Outline application for 51no. dwellings with all matters reserved except for access. This application is a Departure from the Development Plan.

Cinders Nursery & Land R/O Cinders Lane Yapton

Thank you for your internet representation made on 3rd March 2017 which has been recorded as **'an objection'** with the comments as follows:

SURGERY ACCESS VISIBILITY SPLAY (SCALE 1:200)

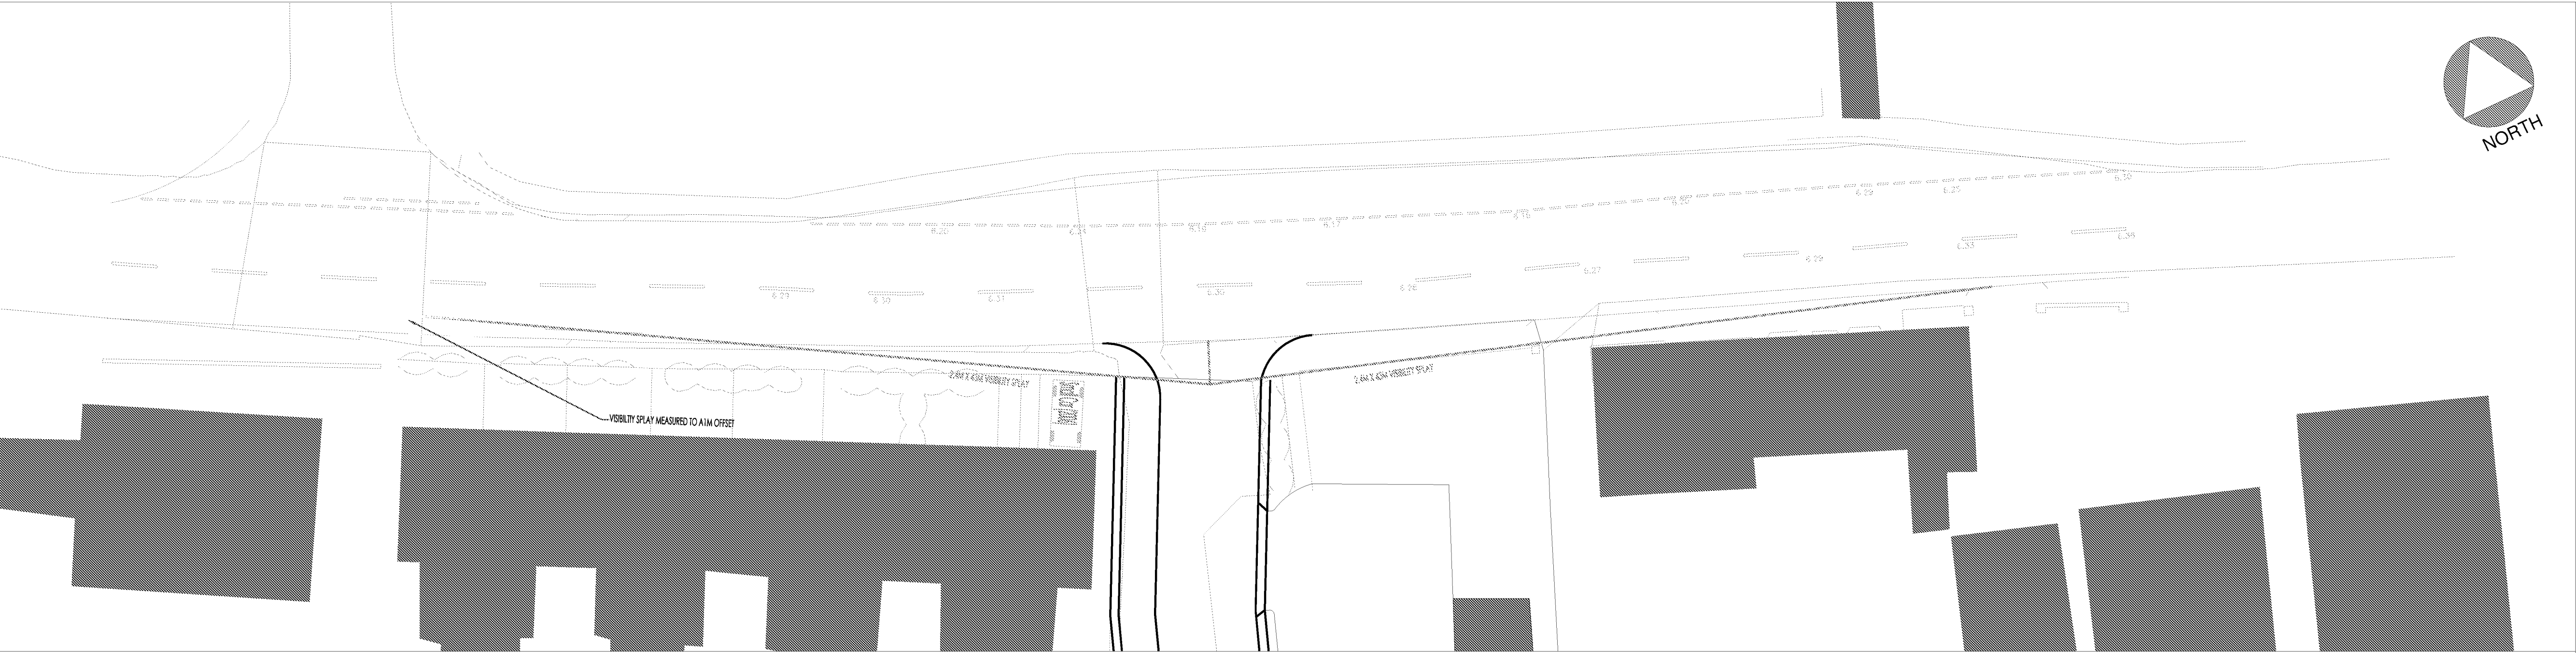
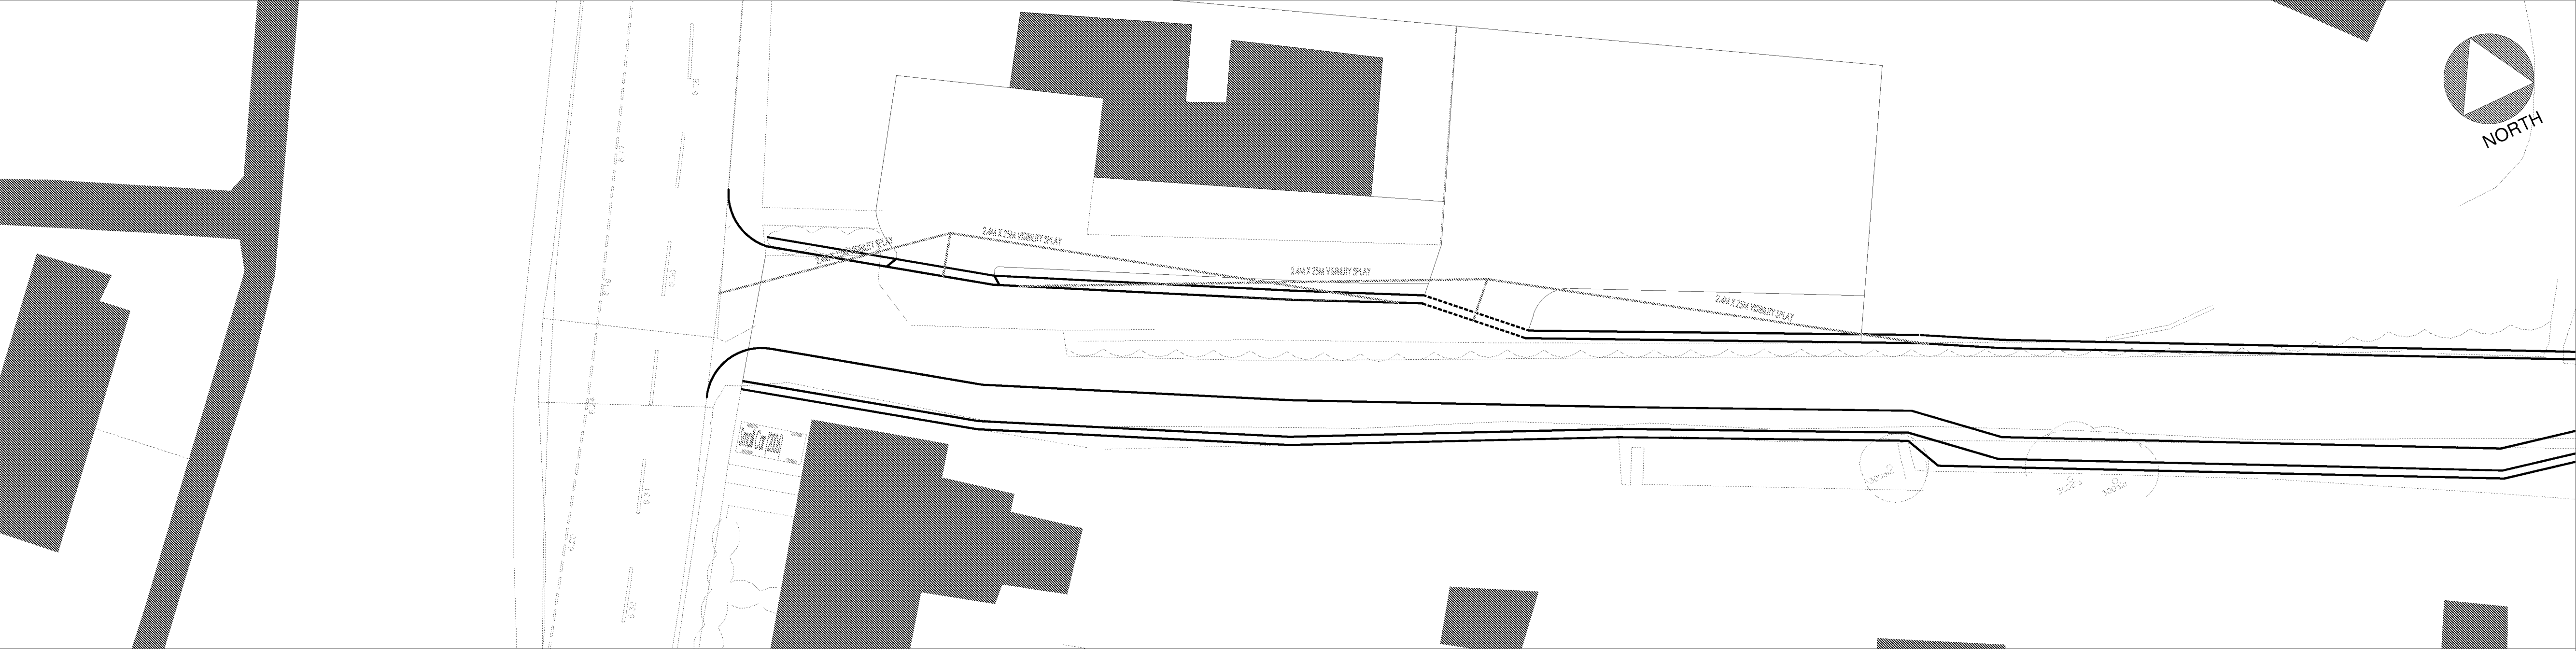
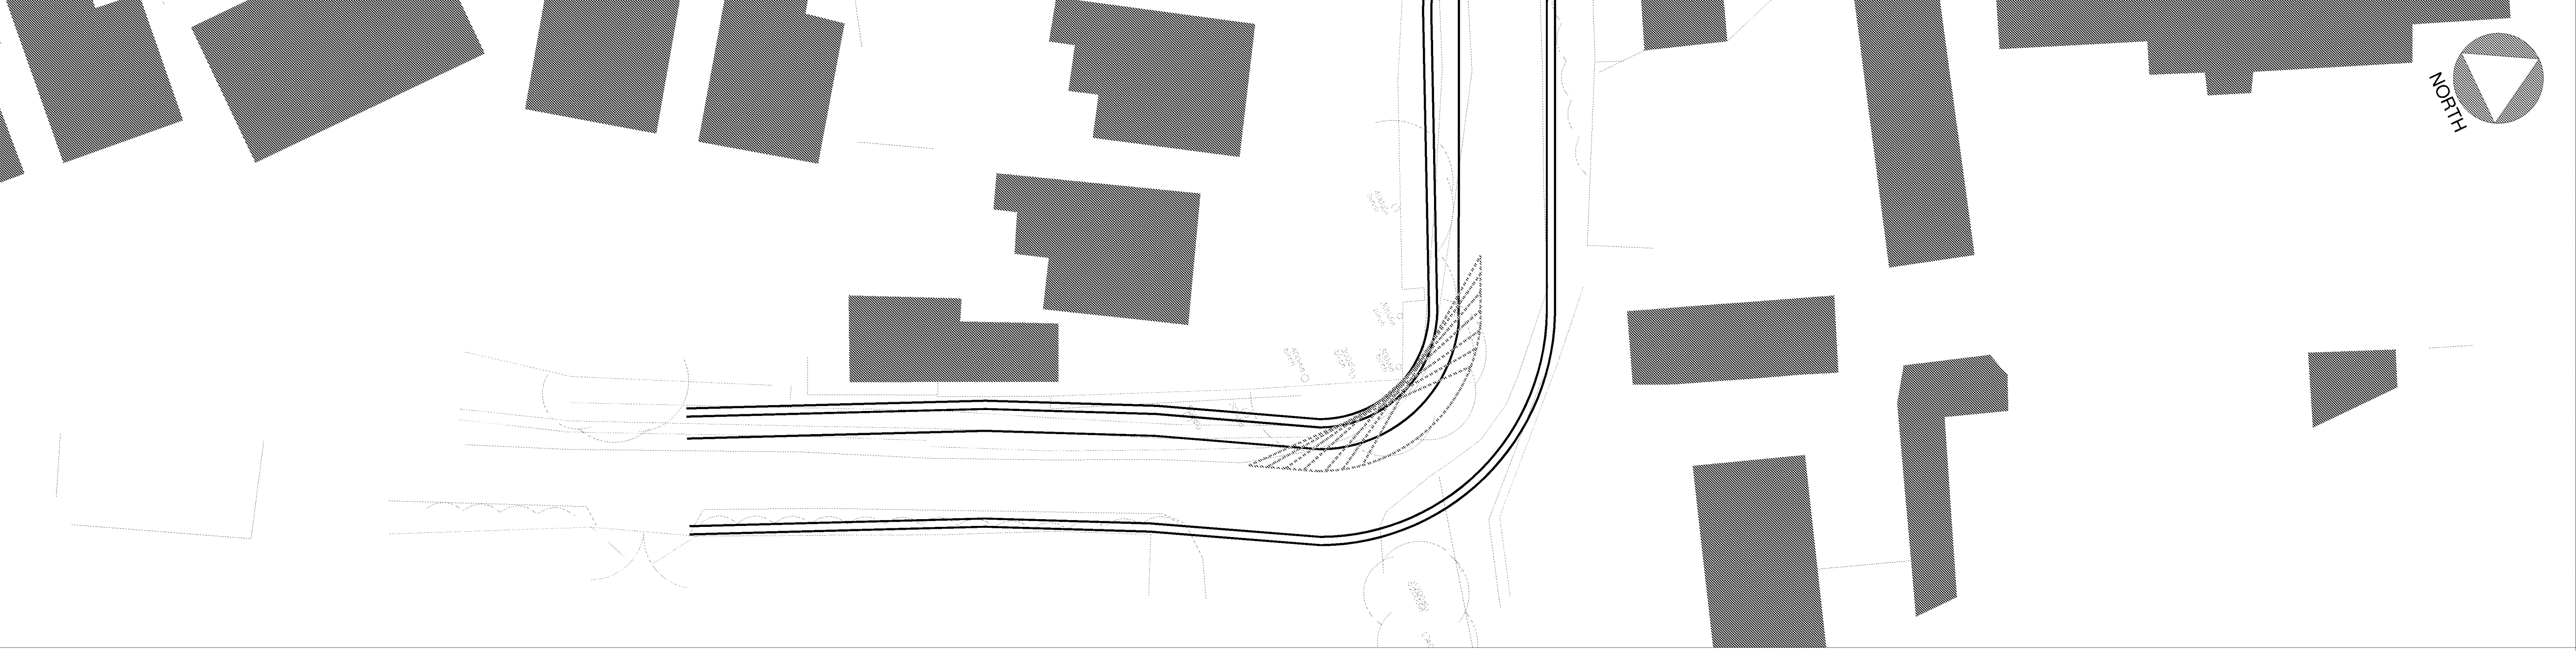
- 1. The drawings submitted appear to widen the road outside Bilsham Road stores and Medway Cottages. this appears to be achieved by removing the pathway for pedestrians. This is unacceptable. This change would remove the parking space outside the store and Medway cottages. Where would the pedestrians and residents cars go. I perceive that they would park elsewhere on Bilsham Road thereby increasing the congestion in that area. Are pedestrians walking to the store simply to "take their chance" when going shopping by walking in the road?*

- 2. The proposal is to widen the access to Cinders lane by changing access to the GP's surgery by setting back entry some 7 meters. This will create a small "T" junction in Cinders Lane. What will happen when cars are exiting Cinders lane and others are trying to access the surgery?*

- 4. Cinders lane is described in the Neighbourhood plan as a narrow track. This is to be narrowed by the provision of a footpath. How will cars coming in and out of Cinders lane pass by each other? Do they mount the pavement or will there be cars parked as people go to the shop?*
